CITY OF ALBUQUERQUE

September 22, 2014

**Re: APS Career Enrichment Center
Scott McGee's Engineer's Stamp 8-25-14 (J15D001)**

Based upon the information provided in your submittal received August 26, 2014, the above referenced plan is not approved for SO-19 nor Building Permit action by the DRB until the following comments are addressed.

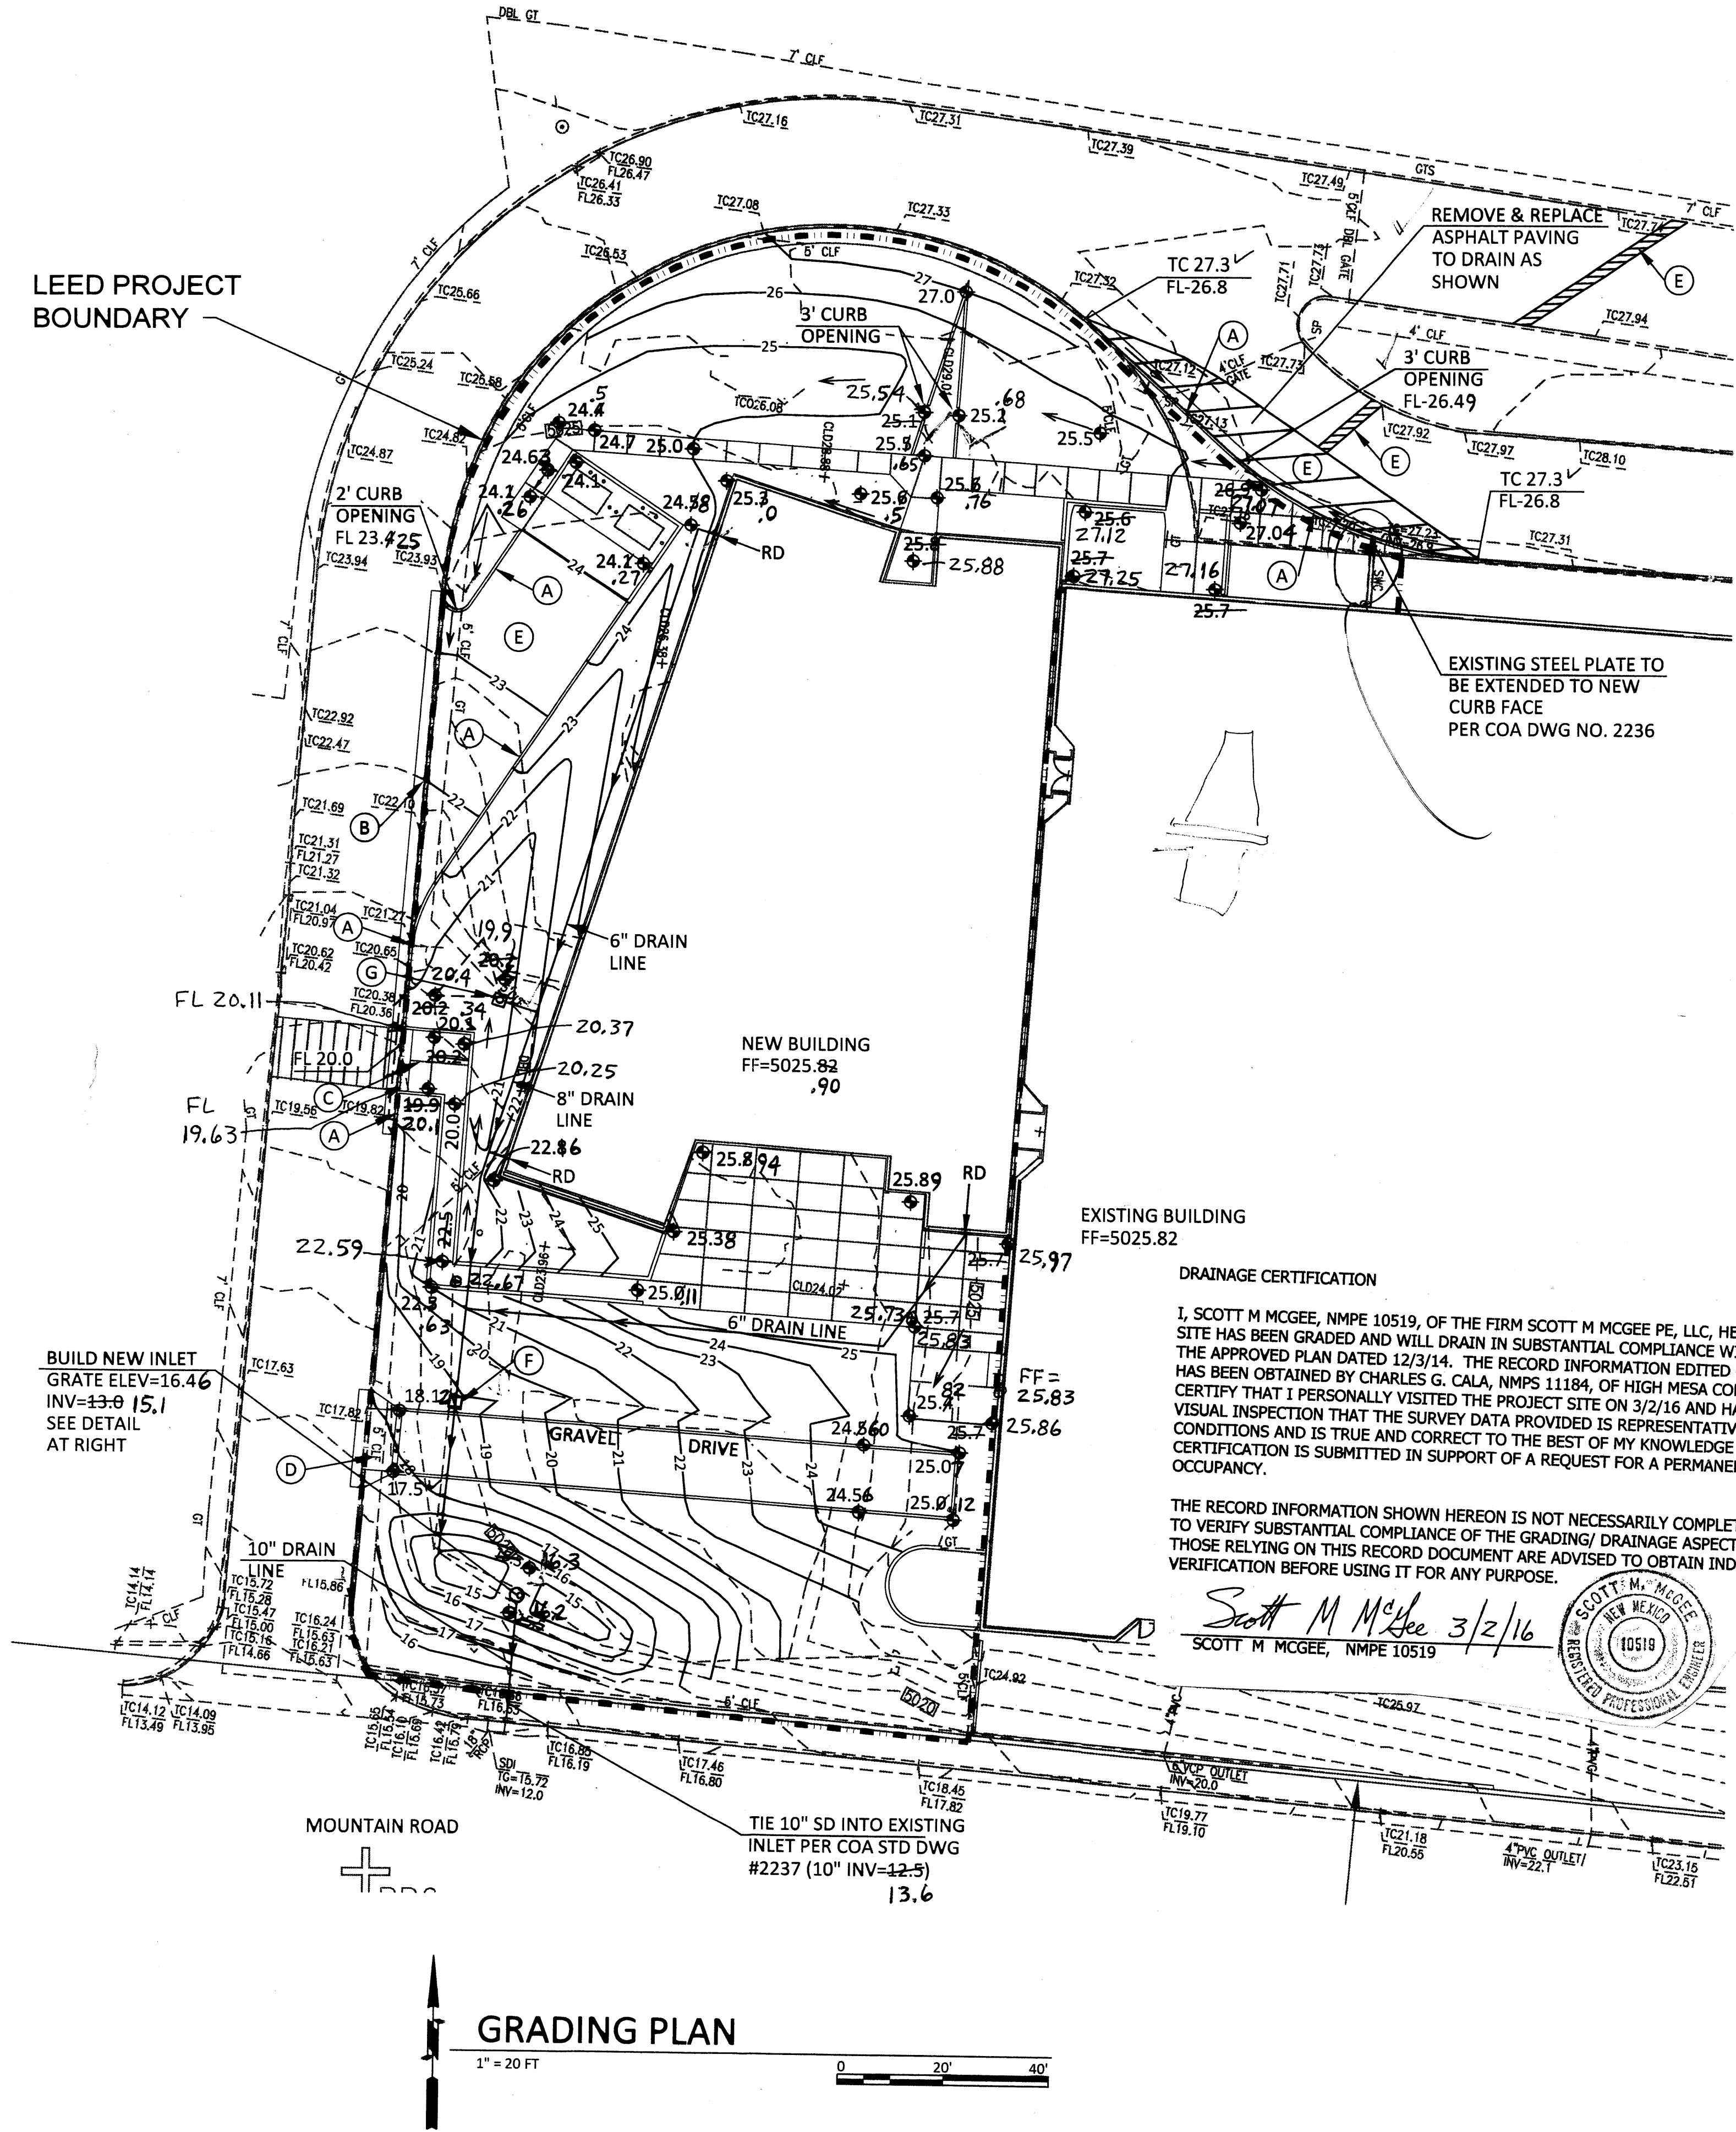
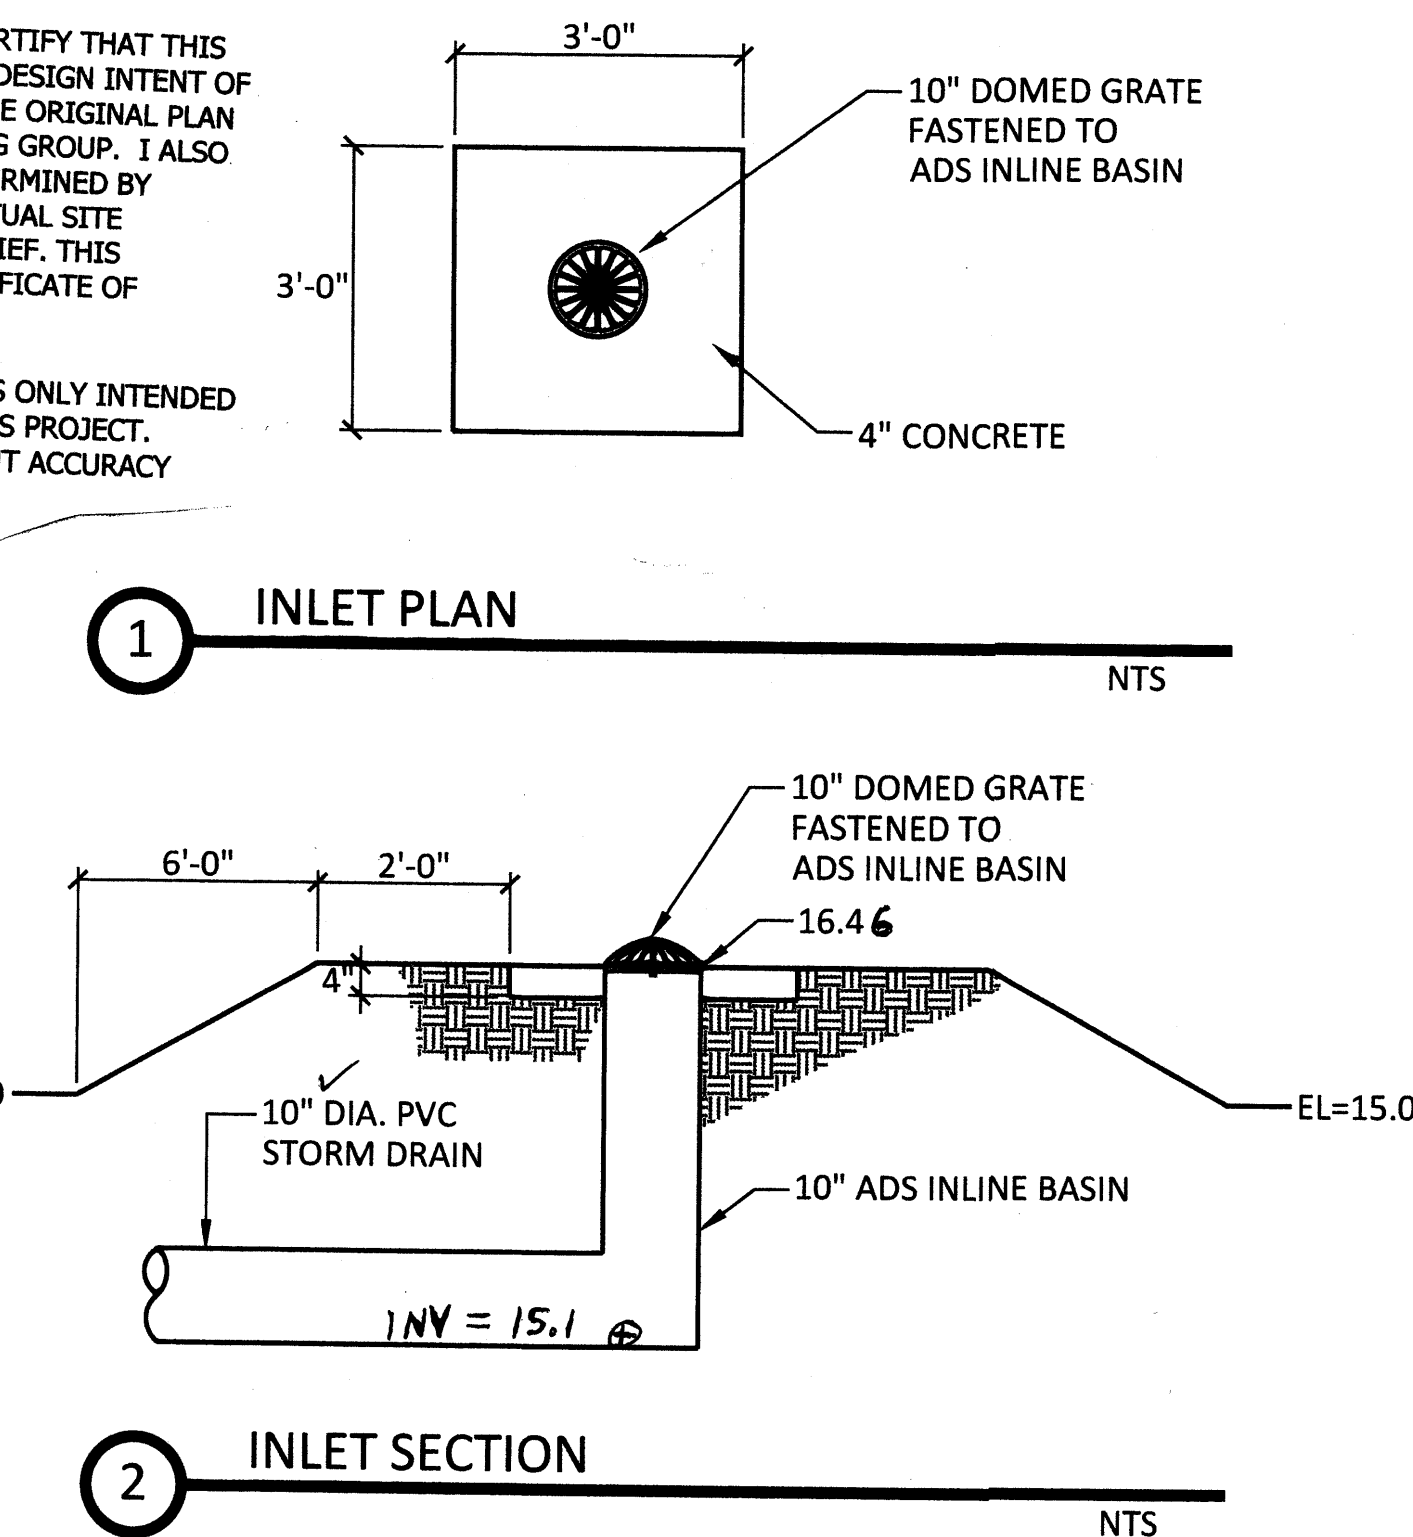
1. Retain the first flush. Per the City Drainage ordinance, the 90th Percentile Storm Event, which is 44 inches, is to be managed. Reduce 0.44 inch by the 0.1 inch for the initial impervious abstraction in Table A-6 of Section 22 of the DPM. Multiply the remaining 0.34 inch by your impervious area. This is the portion to retain.

2. A curb opening and asphalt revisions are being proposed on the northeast corner of the site. The drainage area for this could be sizable and not suitable for going through the proposed swale on the north side of the building. Redesign the grades so that the flows go west and then south along the access road instead.

3. For the proposed flows, discuss the different treatment percentages in the drainage summary.
4. Provide the size of the storm drain accepting flows from the roof drains.

5. The proposed sidewalk on the south side of the building is at 11% which is unacceptable for handicap access. Please revise the grades.
6. Have the utilities such as the overhead lines been removed where the building is being proposed?
